**Consultation Response from KC,
Trees**

2026/90308 Land off, Blackmoorfoot Road and Felks Stile Road, Crosland Moor, Huddersfield, HD4 7AD

Discharge of details reserved by condition 38 (arboricultural report) on previous permission 2024/92614 for variation and removal of conditions 4 (access works), 8 (Blackmoorfoot Road improvements), 10 (junction details), 16 (retaining wall design), 17 (highway structure design), 18 (surface water drainage strategy), 37 (external lighting strategy), 39 (crime mitigation measures) on previous outline permission 2020/92546 (with details of points of access only) for development of up to 770 residential dwellings (Class C3) including up to 70 care apartments (Classes C2/C3) with doctors surgery of up to 350 sqm (Class D1); up to 500 sqm of Class A1/A2/A3/A4/A5/D1 floorspace (dual use), vehicular and pedestrian access points off Blackmoorfoot Road and Felks Stile Road and associated works

Date Responded: 10/02/2026

Tree Impact Plan - Access Arrangements

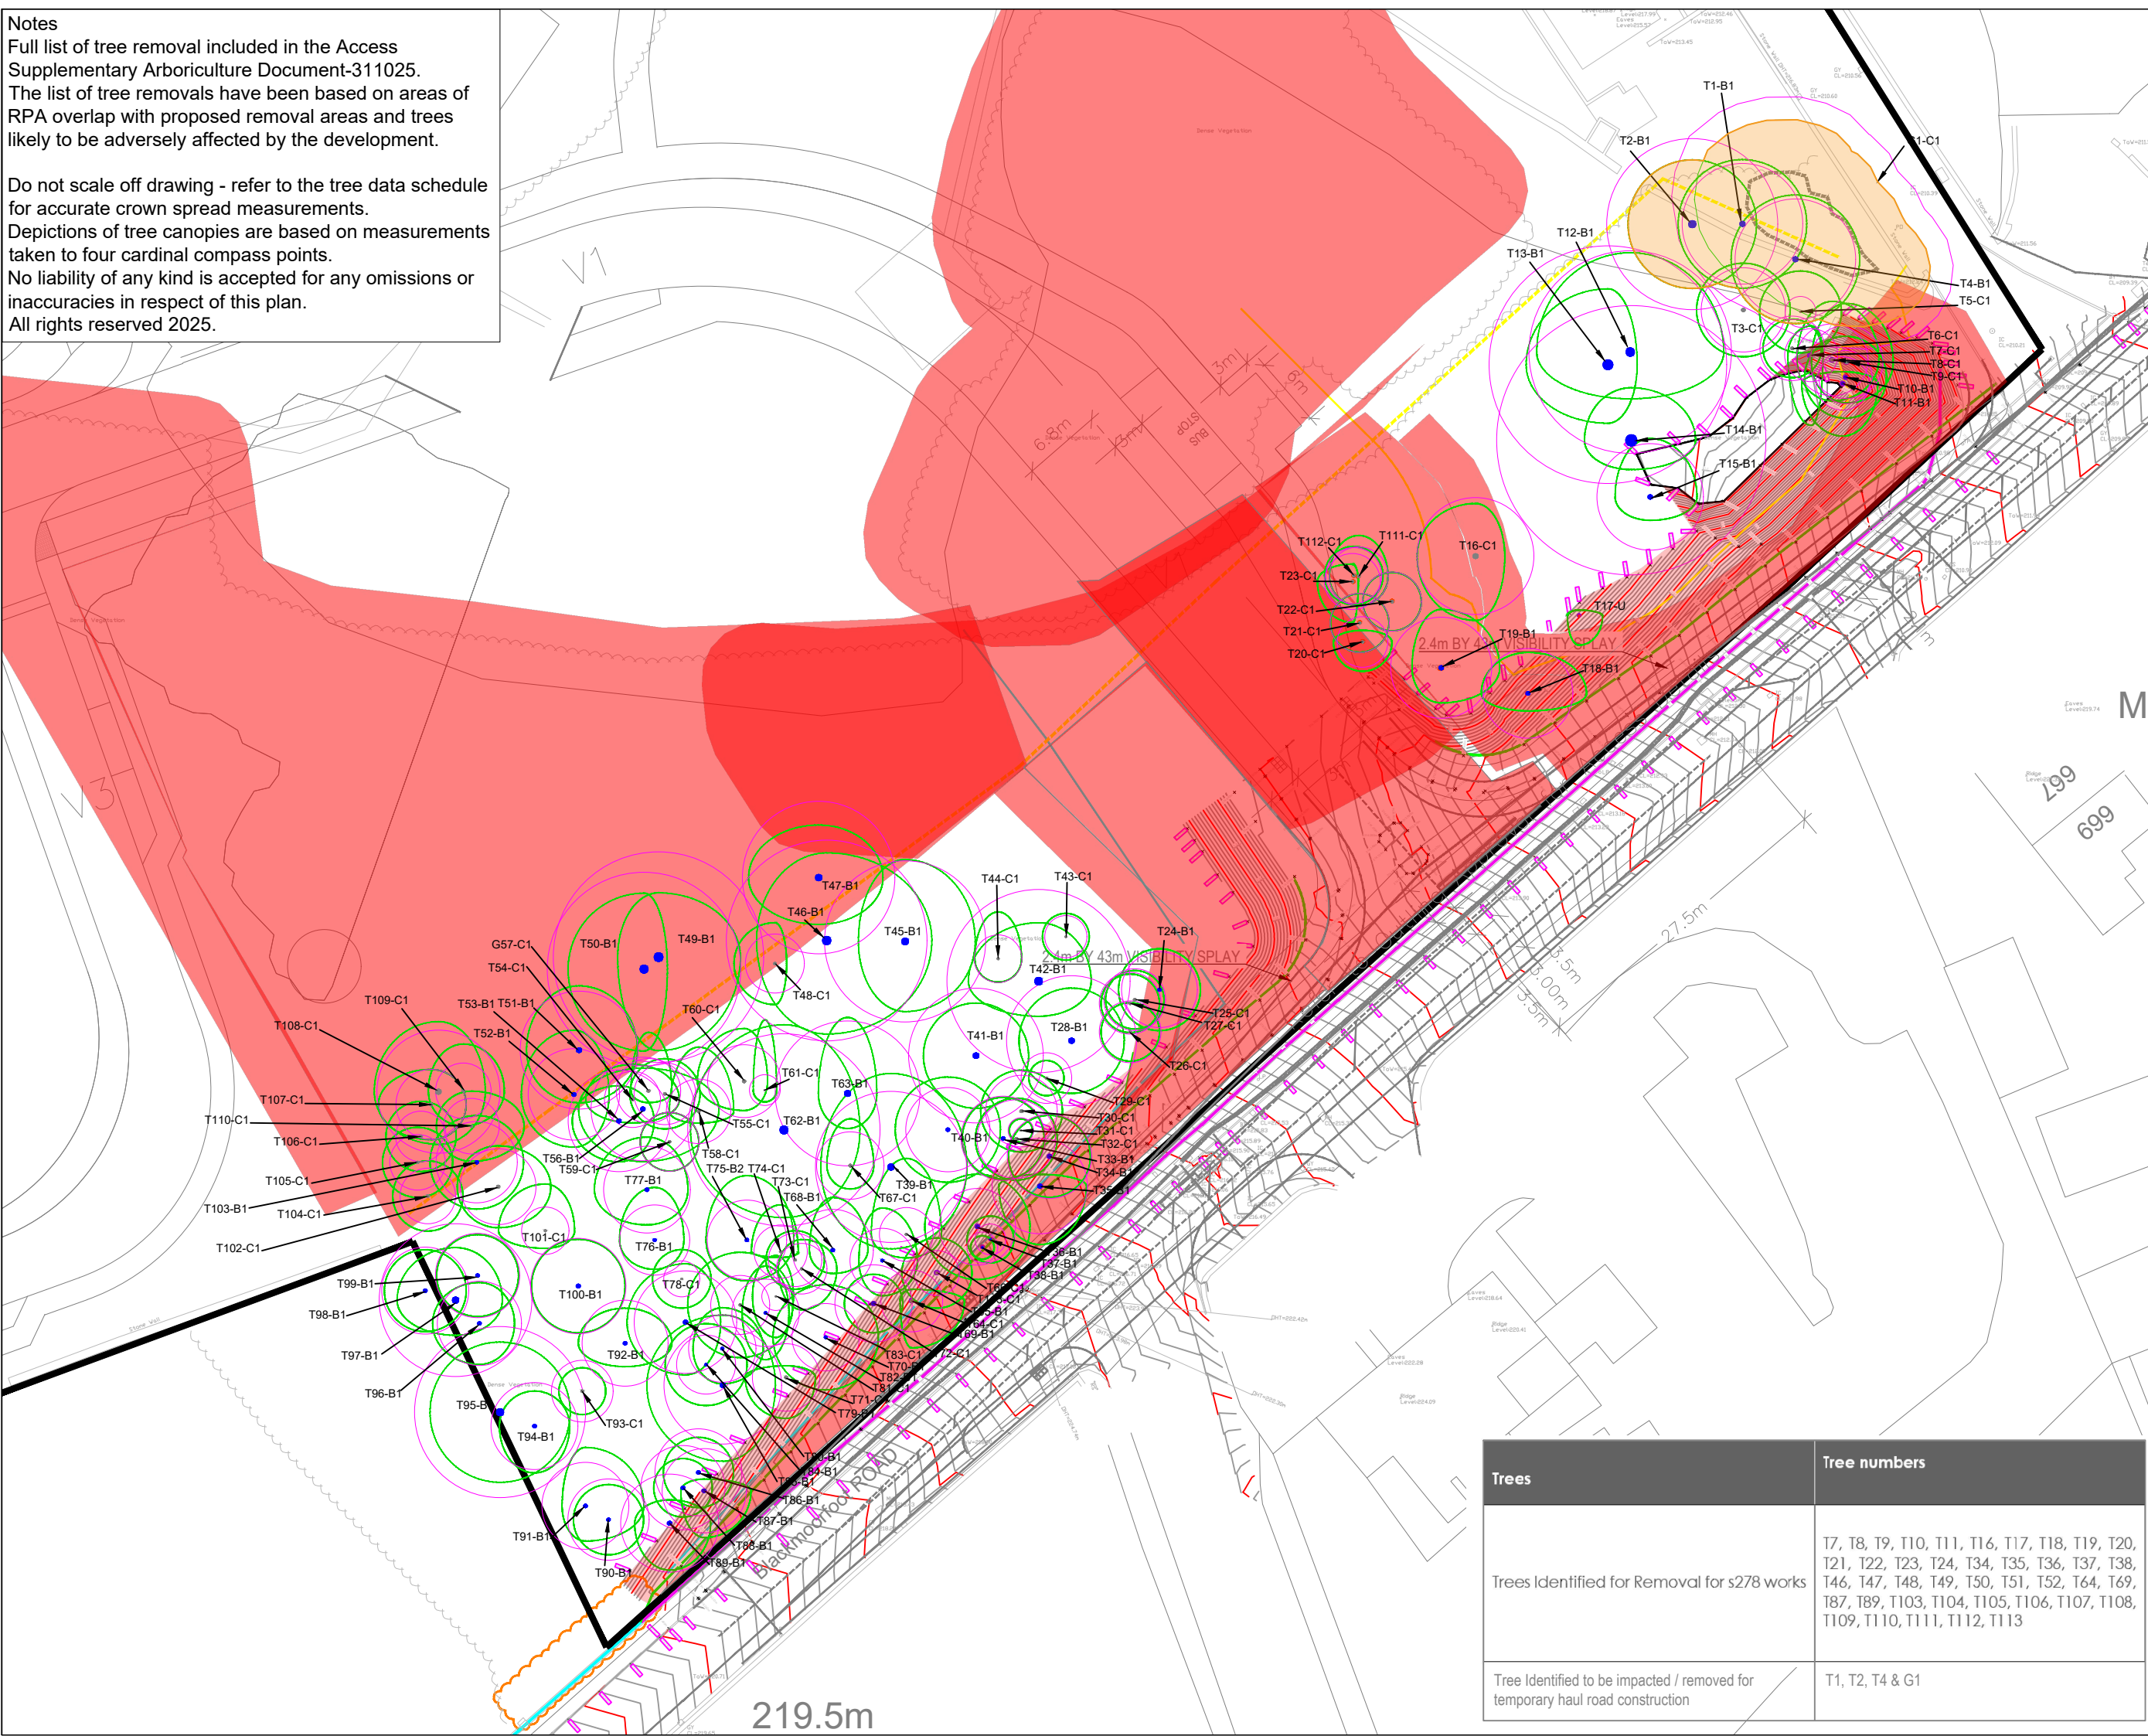
The amount of protected tree removal proposed is above the normal limit of what would be deemed acceptable however it is deemed necessary for highway safety.

In submitted Supplementary Arboriculture Document - P04 161225 it suggests no mitigation is possible for many of the trees removed from this area however across the site there are multiple options for mitigation planting to replace these removed trees.

In this respect KC trees feels condition 38 has not been met and there is a need for a planting scheme to mitigate these losses.
